**WELWYN HATFIELD BOROUGH COUNCIL
EXECUTIVE DIRECTOR - PLANNING, PUBLIC PROTECTION AND GOVERNANCE**

DELEGATED APPLICATION

Application No: 6/2019/0629/HOUSE
Location: The Warren 8 Carbone Hill Northaw Potters Bar EN6 4PL
Proposal: Erection of boundary fence, hedge, brick piers and gates following the removal of existing fence and entrance gates
Officer: Ms Emily Stainer

Recommendation: Refused

Job No 830 Drawing No SP2A

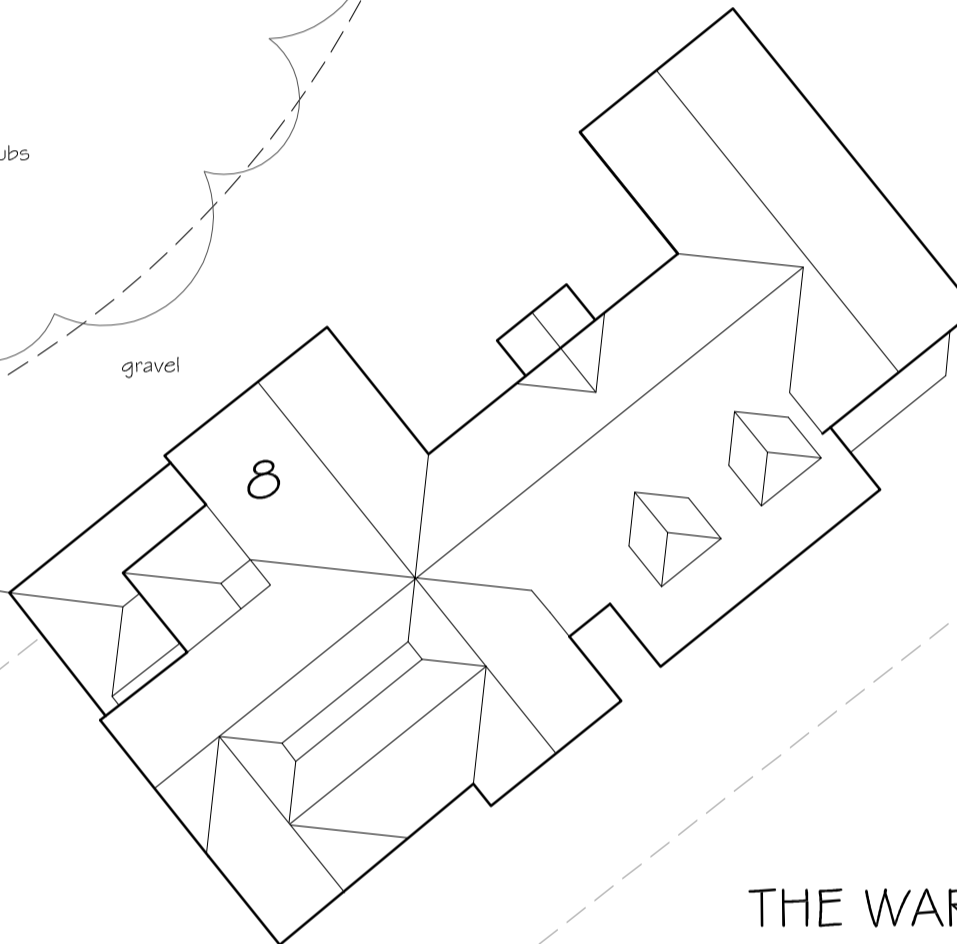
The existing site frontage includes a boundary fence measuring approximately 1 metre in height and two timber gates. It is also densely screened with trees and shrubs, which limit views into the site. The proposed close boarded fence would be 1.5 metres high, with a 1.2 metre hedge running along the front of it. The hedge would be mixed native consisting of species such as field maple, hornbeam, hawthorn and beech which assist in not only softening the appearance of the hard-boundary treatment, but also contribute to the character of the street scene.

The height and design of the brick piers and walls would however be at odds with the predominantly open landscaped character of the street scene. The structure cumulatively represent a grandiose urban feature along the entire site frontage - emphasised by the extent of solid and bulky piers, walls, connecting fence and overall scale. For these reasons, it is considered to be a prominent and visually intrusive feature in the area.
